Martin Nugent
01254 828060
D3/11/0550

Drafted 16 September 2011

**Planning Application, Ribble Valley District
3/11/0550 Elan Precision Engineering, Waterloo Road, Clitheroe**

EXISTING SITE PLAN
 1:100

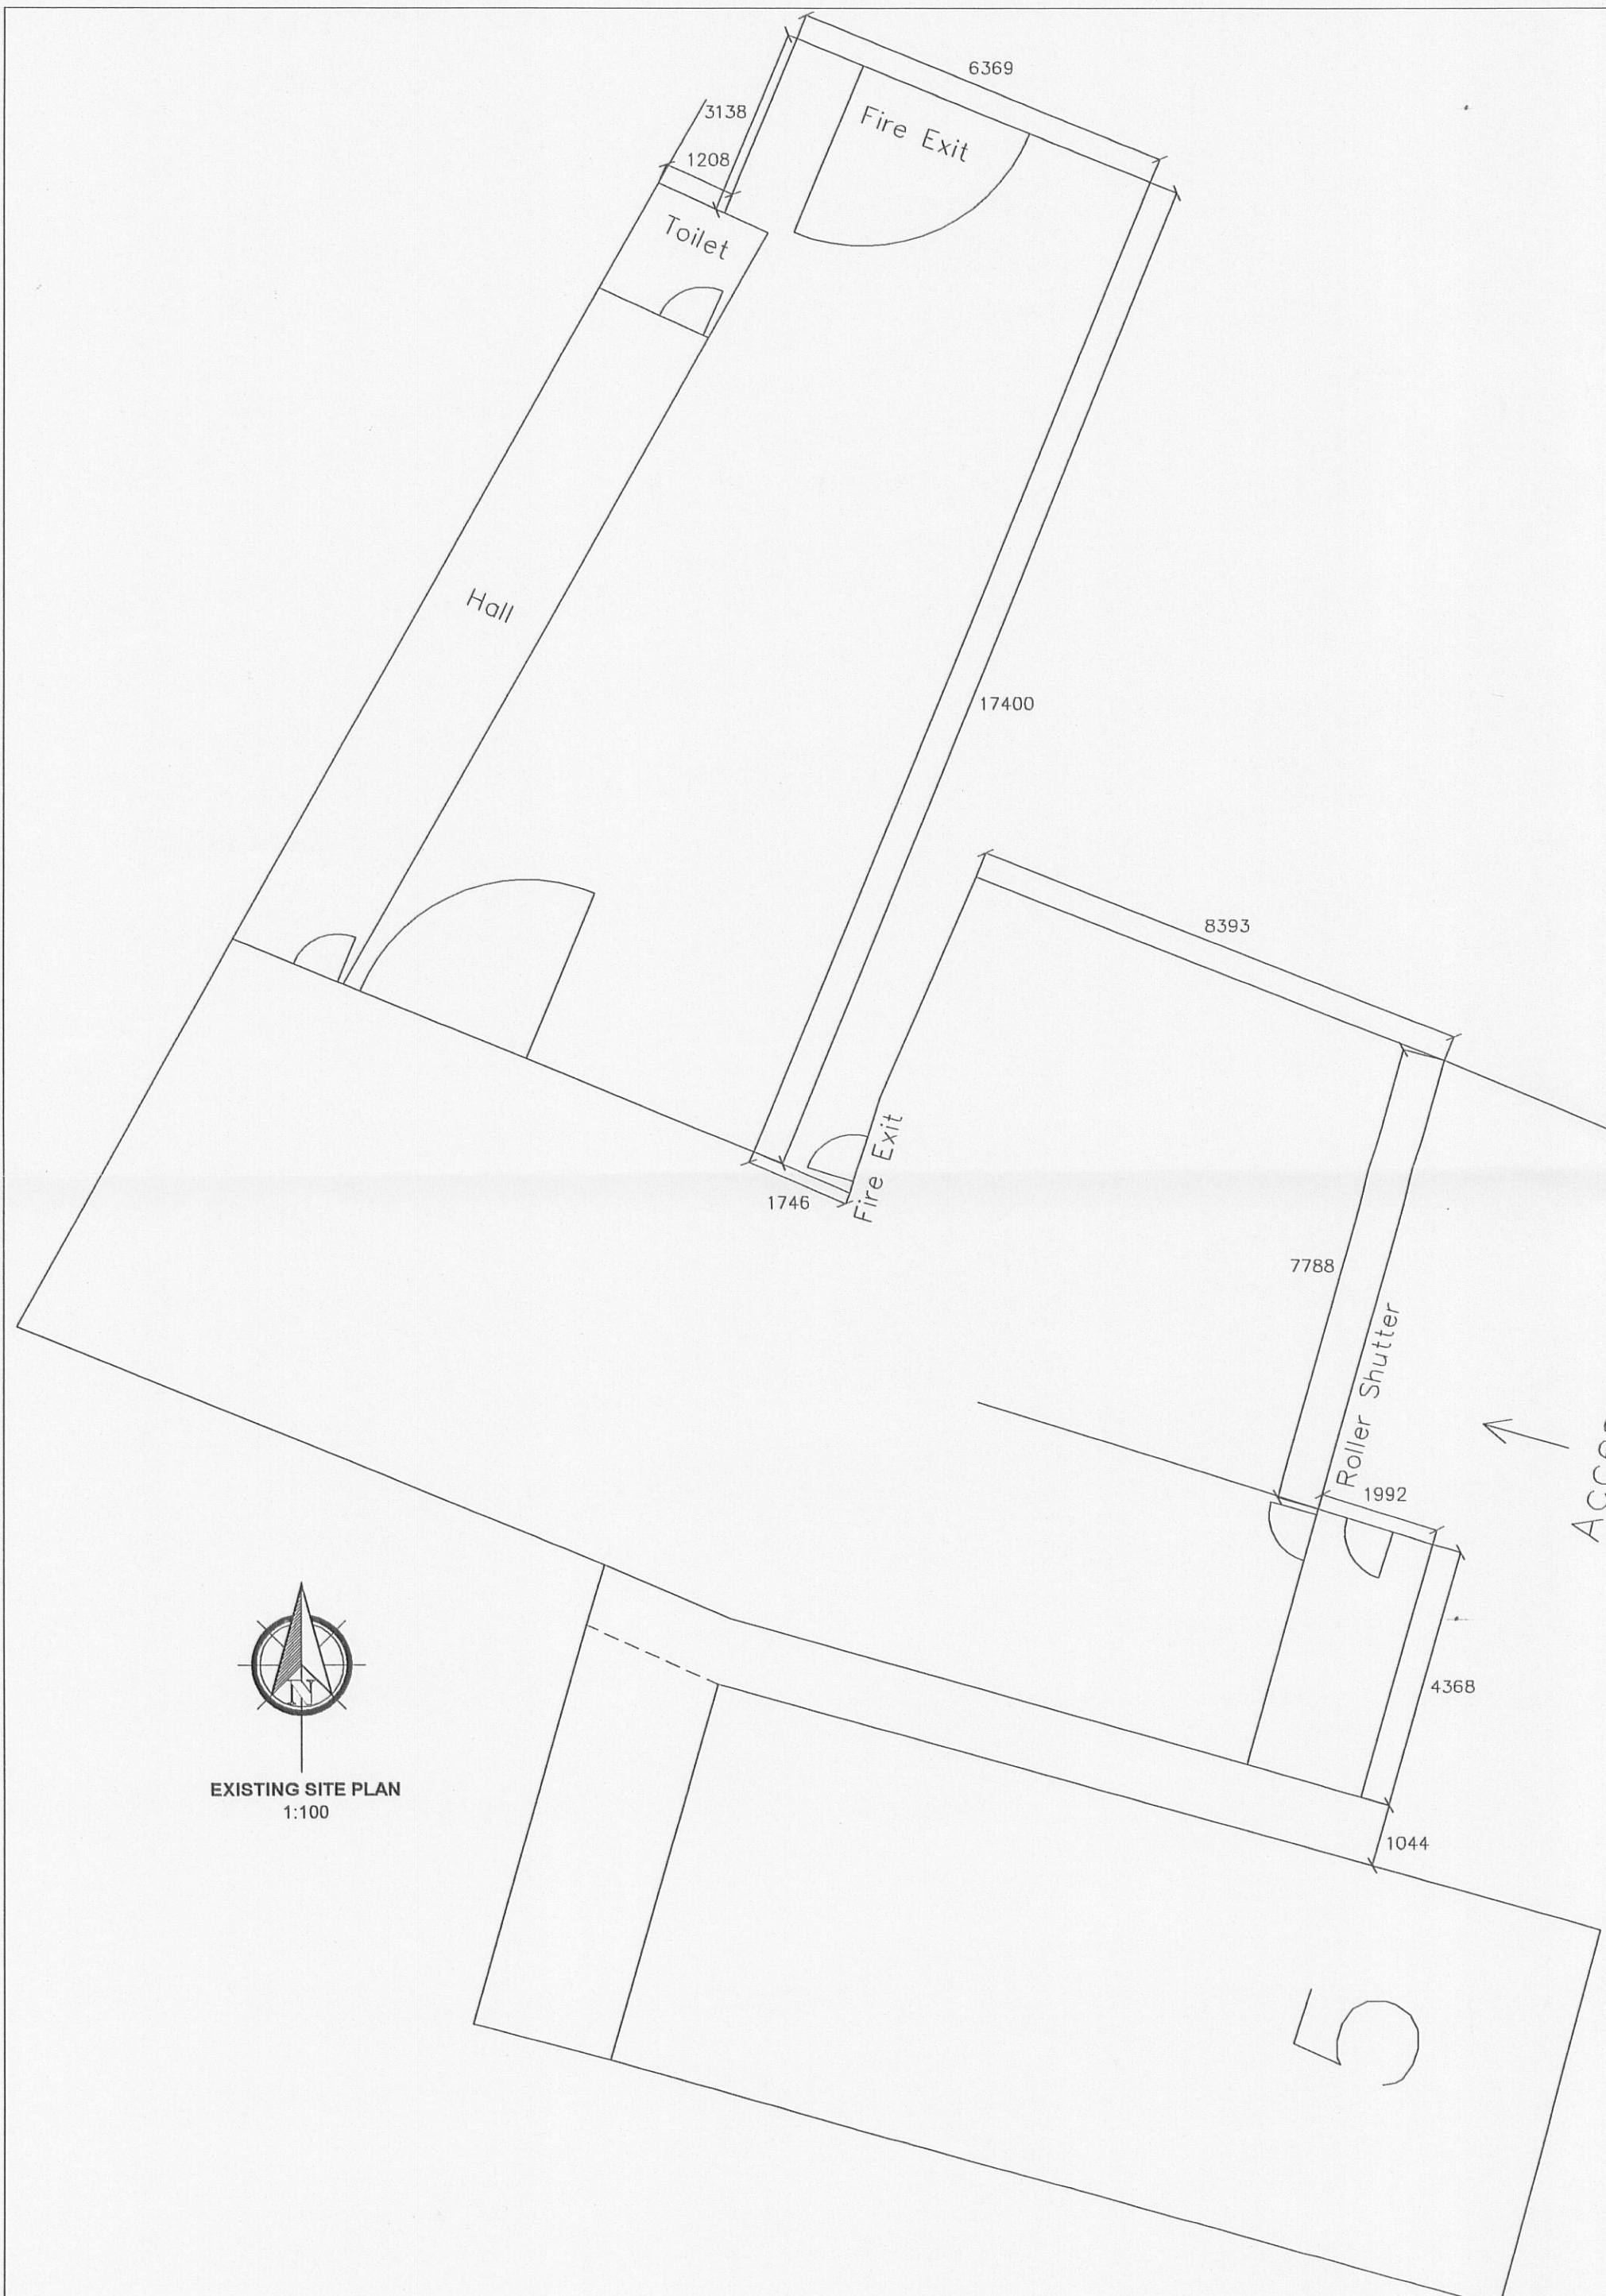
The development provides a suitable means of access to the facilities and an adequate provision for car parking within the immediate frontage.

In the design and operation of the car washing facility, measures must be taken to insure that water does not intrude into the adjacent parking areas or onto the nearby highway, as this would introduce an unwarranted hazard and be detrimental to the safe movement of traffic.
